YANCO BATTERY ENERGY STORAGE SYSTEM (SSD-67478479) – RESPONSE TO REQUEST FOR FURTHER INFORMATION

We refer to your request for further information by email of 26 May 2025, in relation to the Yanco Battery Energy Storage System (BESS).

Figure 1 | Proposed site access

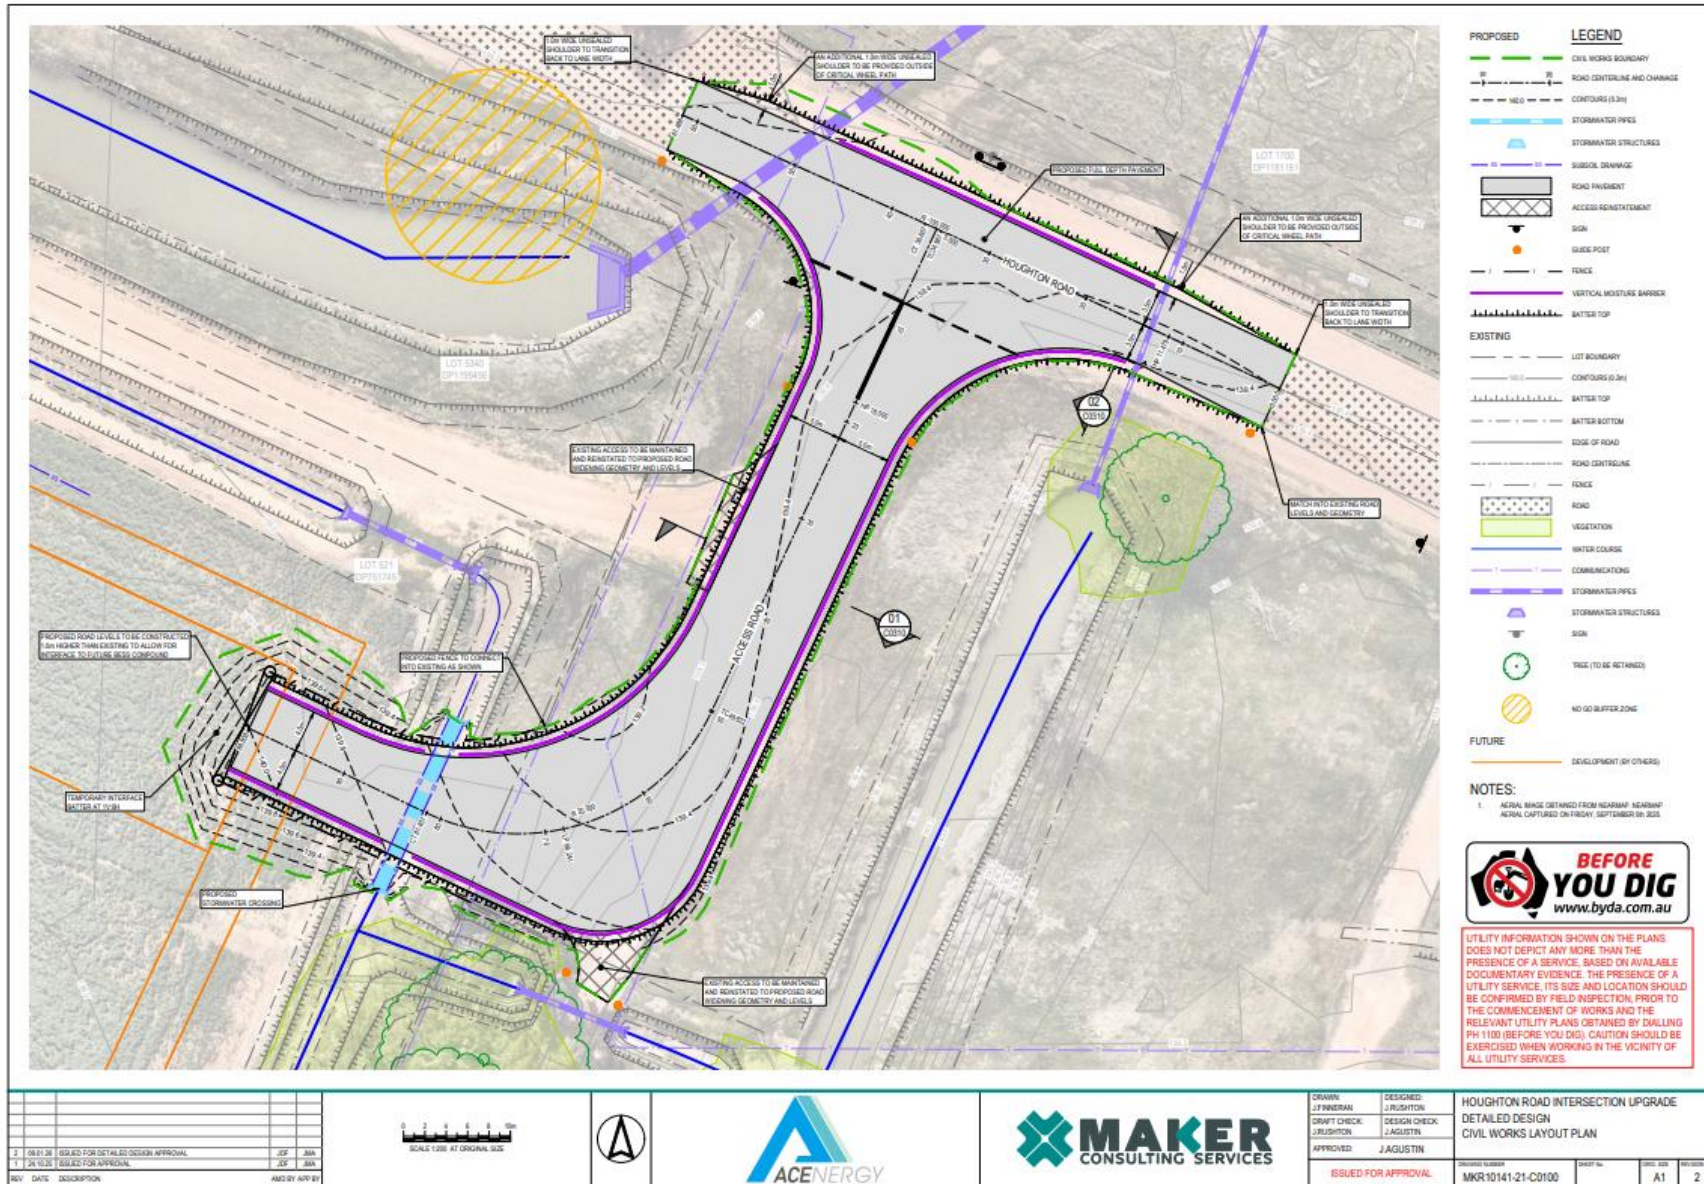
RFI	Response
improve this - or change to colour / weight of lines) > Include R3 and R8 > Provide as a high-resolution JPEG	
Traffic > What is the site access being constructed as? Rural property access etc.	It is confirmed that the property access would be constructed as a standard rural property access in accordance with Figure 7.4 of Austroads Part 4, noting that it would accommodate the project design vehicle, i.e. 19 m semi-trailer, and 12x8 Platform Carrier (as assessed in the OSOM Route Study).
> Do you have any heavy vehicles requiring escort that are not high risk. Or do you only propose to use heavy vehicles and high-risk heavy vehicles requiring escort?	There are estimated to be a total of 11 vehicles requiring escort, two of which are high risk. These two movements are the transformer deliveries. The non high risk deliveries are the two switch rooms, two sets of busbars, two cranes, one control room, one O & M room, and one set of concrete poles.

Figure 2 | Irrigation Way / Houghton Road intersection upgrades

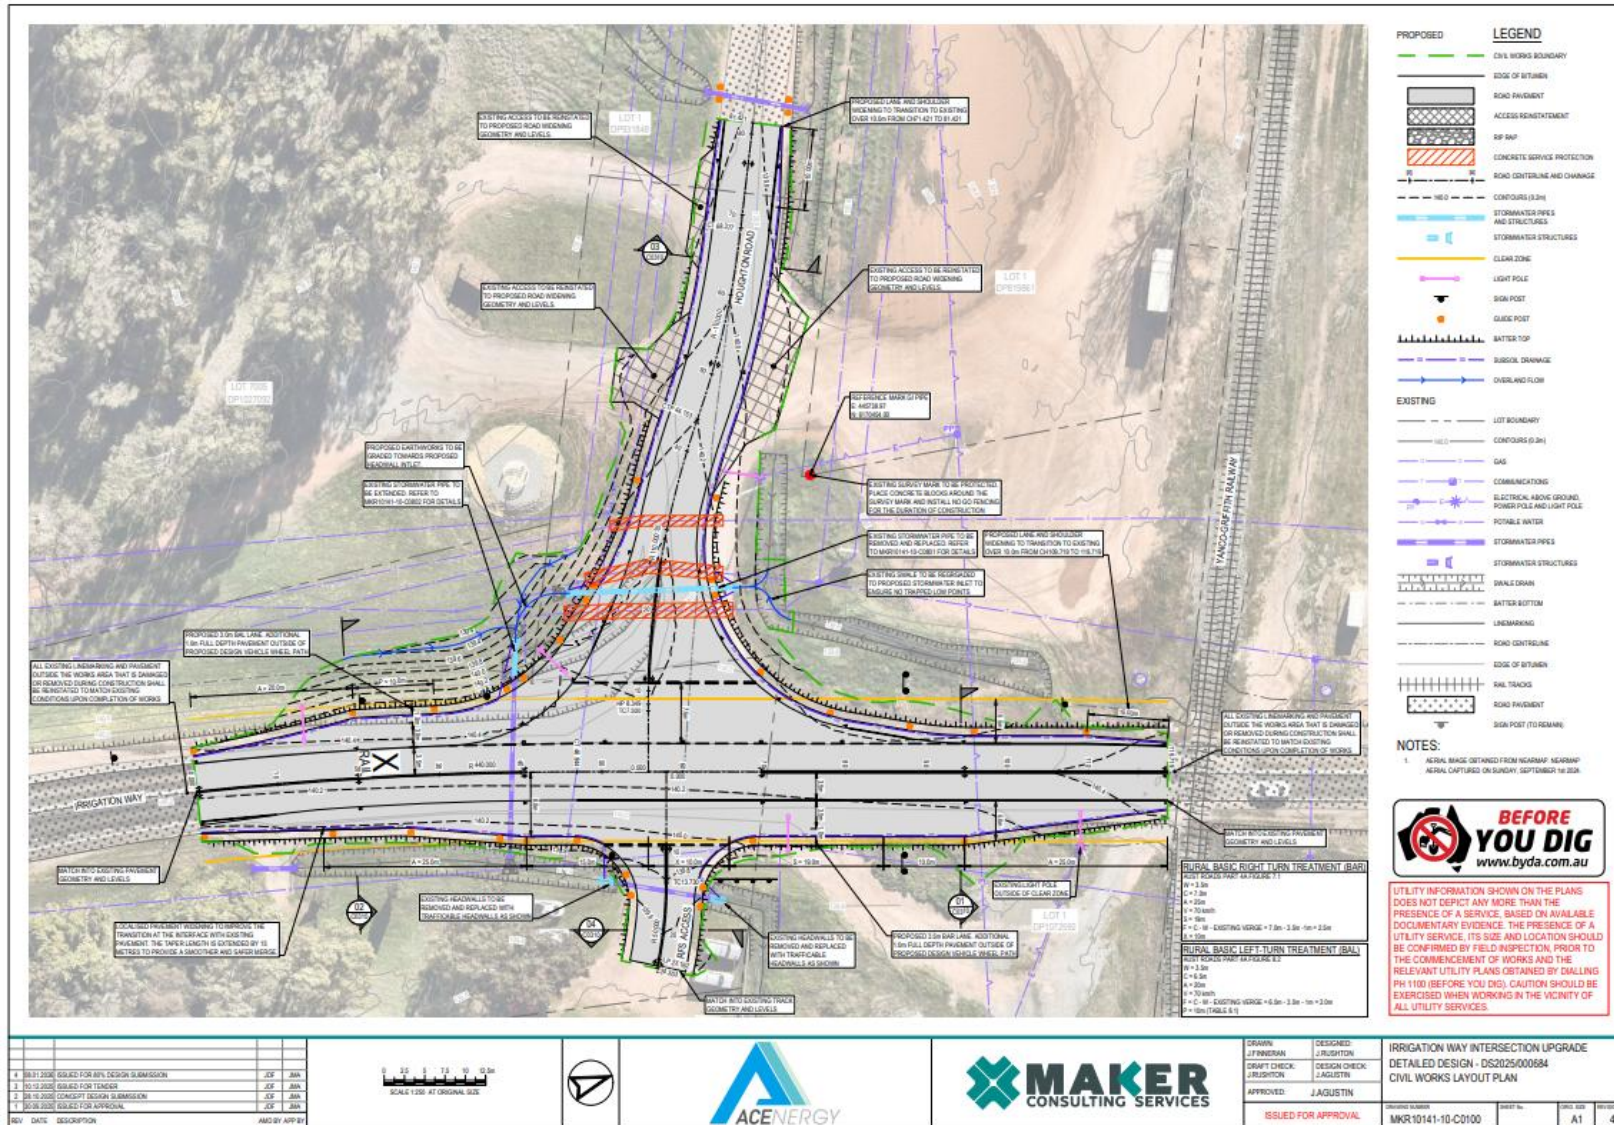
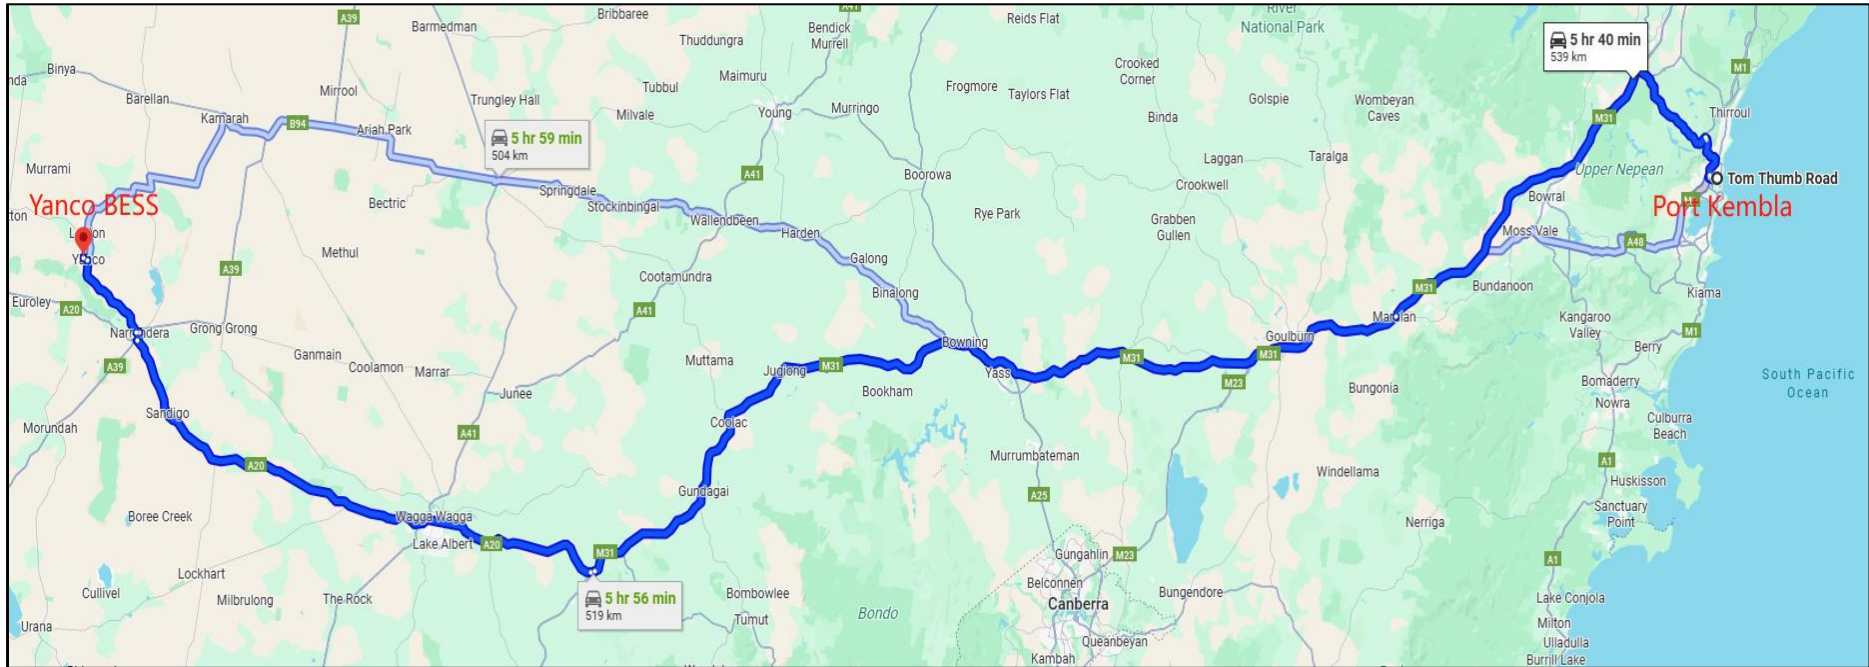
Impact	Phase	Mitigation Measures
		> The intersection of Irrigation Way and Houghton Road should be upgraded in accordance with the prepared Strategic Design plan to include BAR and BAL treatments per the prepared Strategic Design plans. > Install signage and line marking north of the railway line to advise drivers not to store between the railway lines. > Implement a traffic management plan to ensure all staff are instructed not to store across the railway lines. > The intersection of Houghton Road, Hume Road and the subject development site access should be upgraded in accordance with the prepared Functional Layout plan Strategic Design plan. > Implement a traffic management plan to ensure no heavy vehicles arrive and depart simultaneously along Hulme Houghton Road. > A code of conduct will be included in the traffic management plan for the construction period to promote safe behaviour when commuting to the worksite. > Four 22-seat shuttle buses will be provided to reduce traffic vehicle movements during the construction period. Staff movements will be serviced by the shuttle buses as follows: • 2x for Yanco • 1x for Griffith • 1x for Narrandera > The applicant commits to undertaking an independent dilapidation survey to assess the: • condition of Houghton and Hulme Roads, prior to construction, upgrading and decommissioning activities; and • condition of Houghton and Hulme Roads, following the completion of construction, upgrading and decommissioning activities; > on completion of the dilapidation reports, provide a copy to the relevant roads' authorities; and > repair and/or make good any development-related damage to Houghton and Hulme Roads identified in dilapidation surveys during construction, upgrading or decommissioning works in consultation with the relevant roads authority. > contact UGL and obtain rail operation schedule after development consent and prior to construction, and incorporate the schedule into Traffic Management Plan to be endorsed by TfNSW. > Management Plans shall include a requirement signalling departing vehicles via radio to ensure no heavy vehicles are arriving at Houghton Rd. > The applicant commits to including procedures in the TMP associated with navigating pinch points along the route for high risk over-dimensional vehicles requiring escort, including but not limited to timing of manoeuvres (particularly for the University
